Application No: EP/128/20/HH
Site Address: 48 Angmering Lane East Preston BN16 2TA
Description of works: Erection of a two storey rear extension. Existing brick house to be rendered in white with alterations to fenestration

Thank you for your internet representation made on 23rd November 2020 which has been recorded as an objection with the comments as follows:

Proposed First Floor Plan

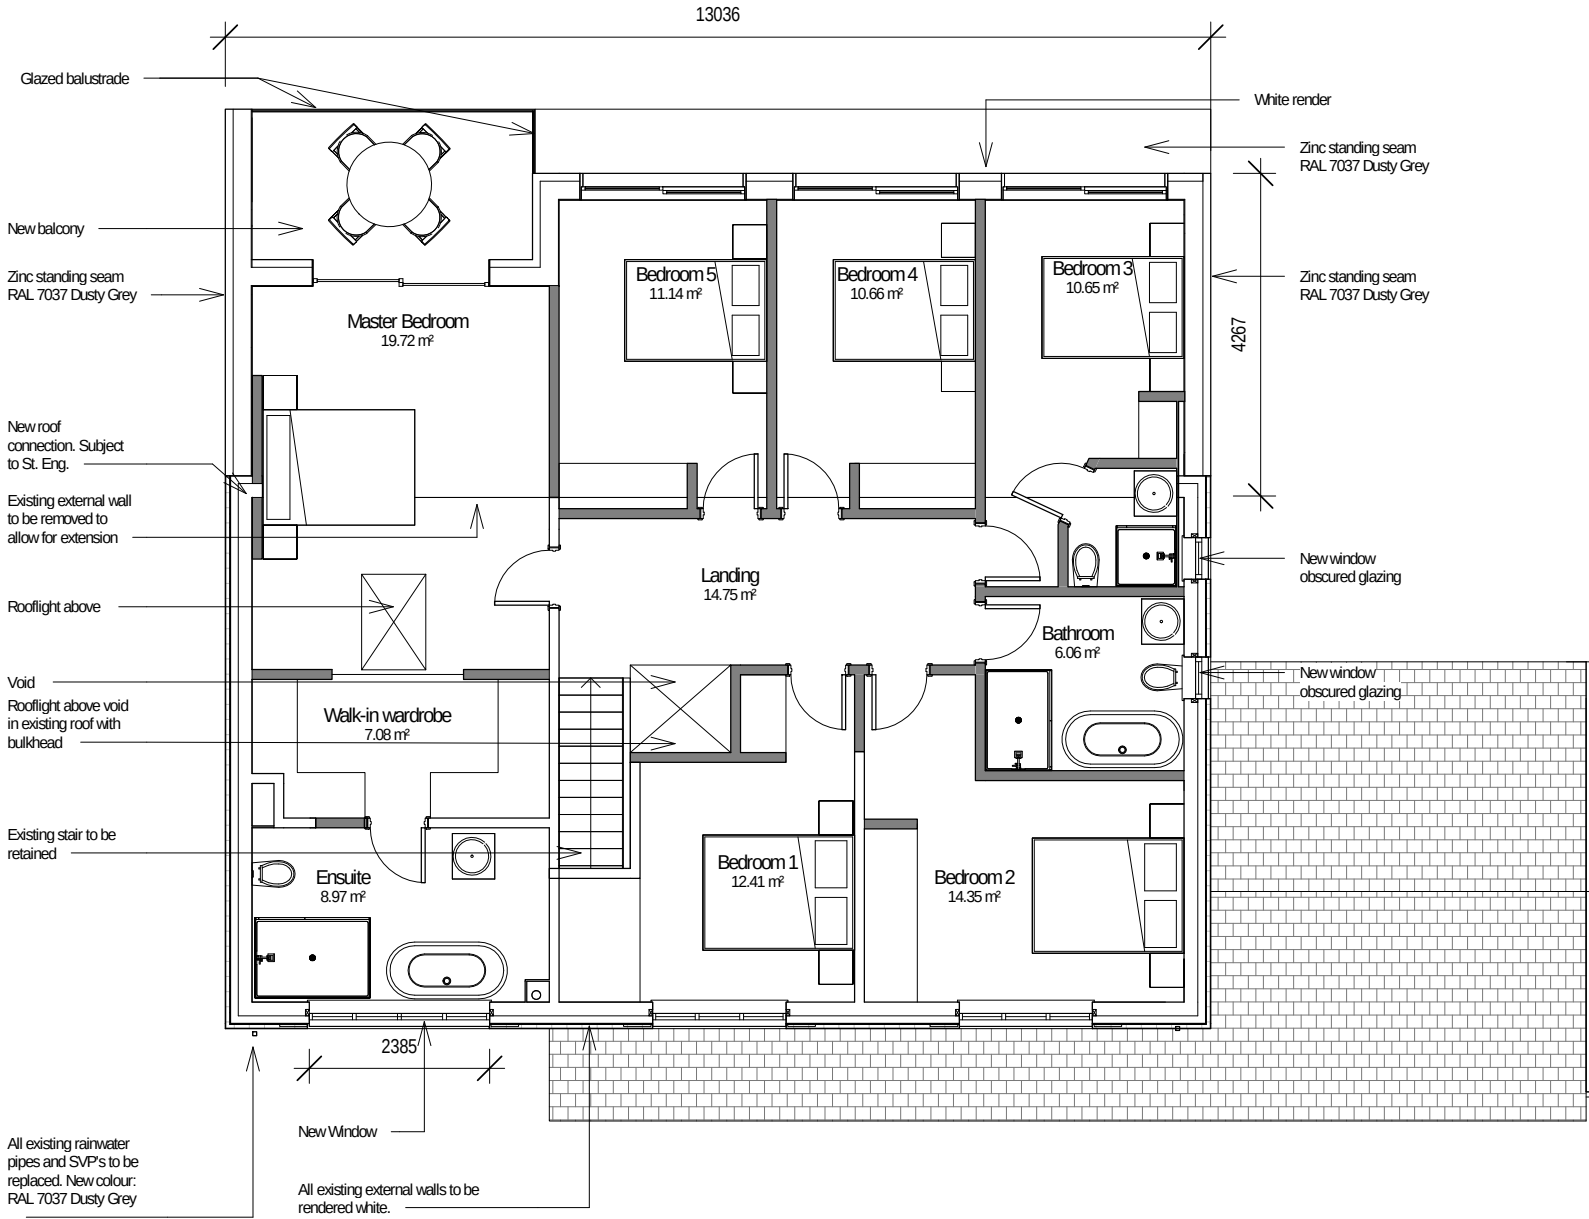
I refer to my previous objections of 17/11/20 and the revised planning application. I am pleased to note that the grey cladding has been replaced by white rendering. However my objection to the first floor balcony remains. It entirely removes any privacy from our garden. Anyone sitting there would have an unrestricted view of any activity included that of our young grandchildren playing plus any socialising we may do with friends. It is also notable that the balcony extends beyond the rear building line. I was unable to find how far it extends. It is also not in keeping with neighbouring houses.

Drawing No. 0010 Drawing Name: Proposed Elevations

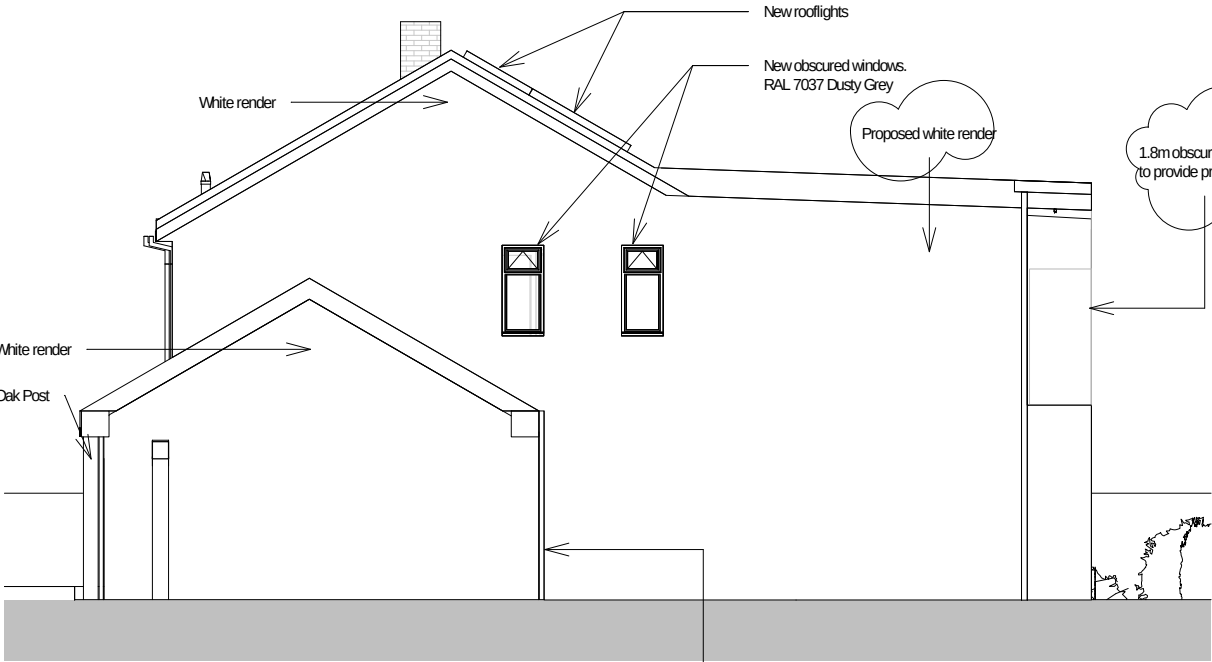
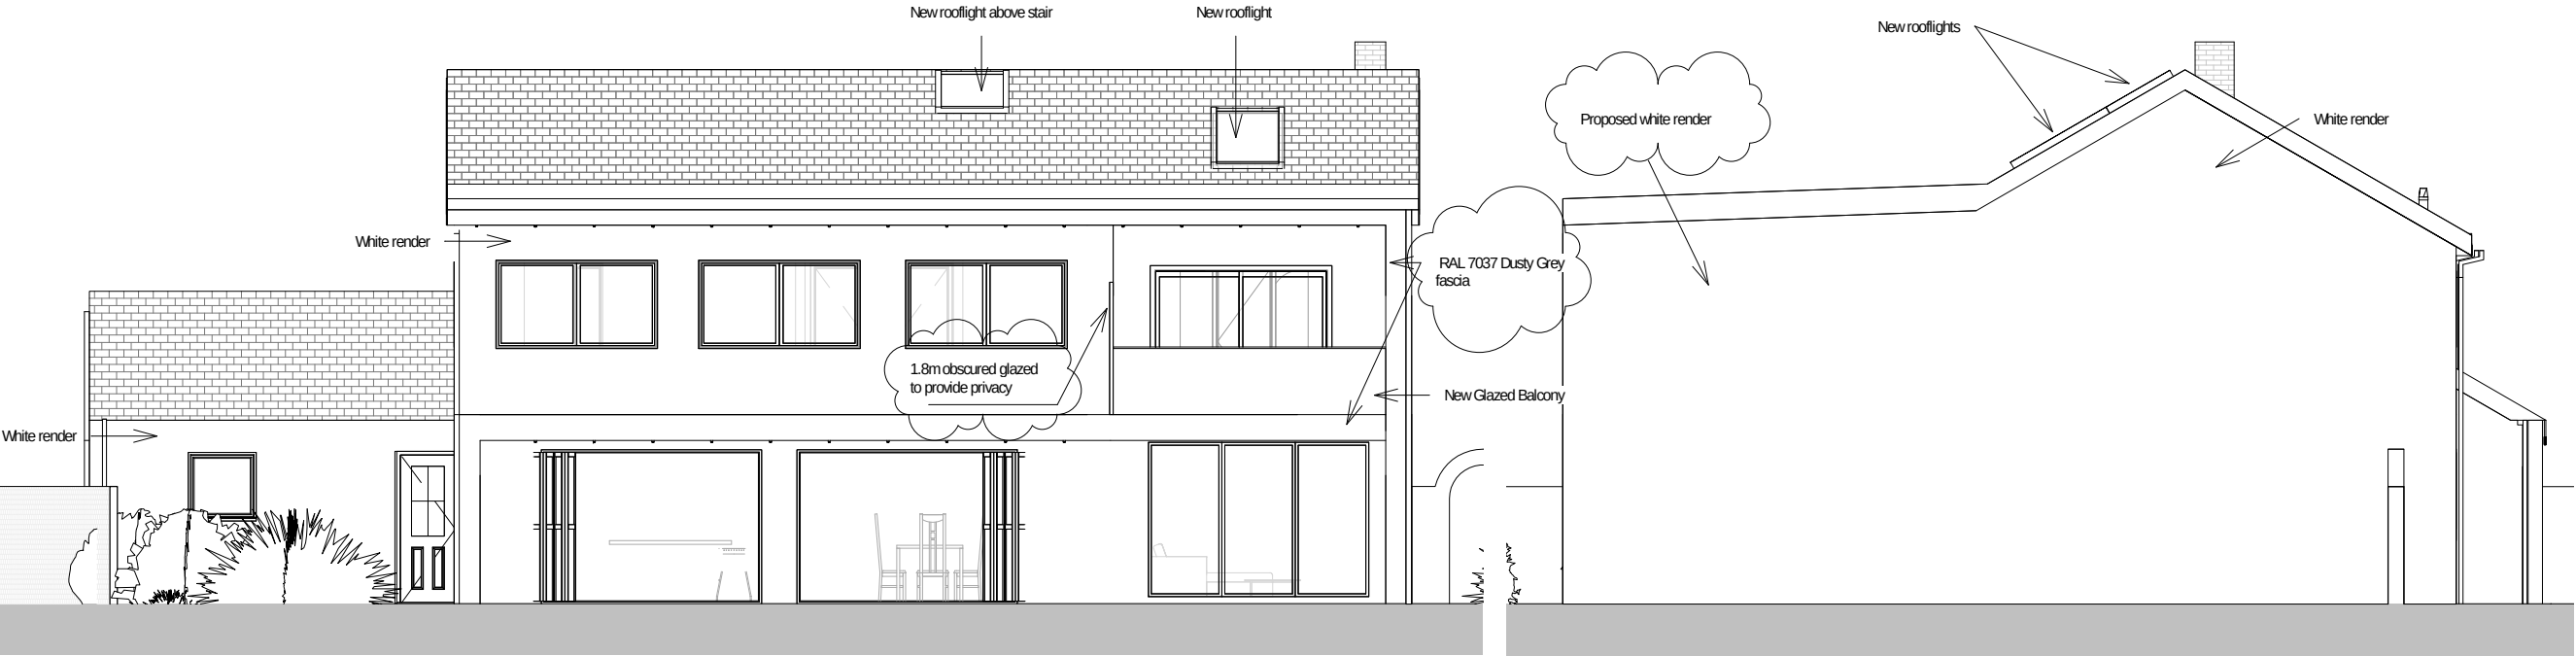
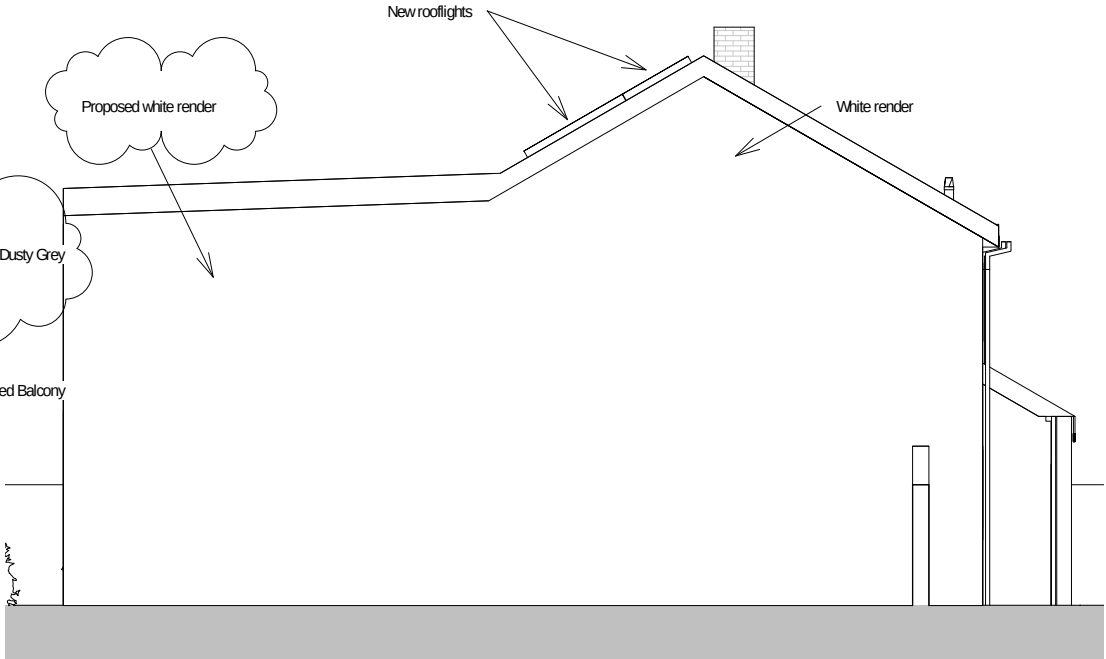
The previous comments re the flat roof and its height remain.
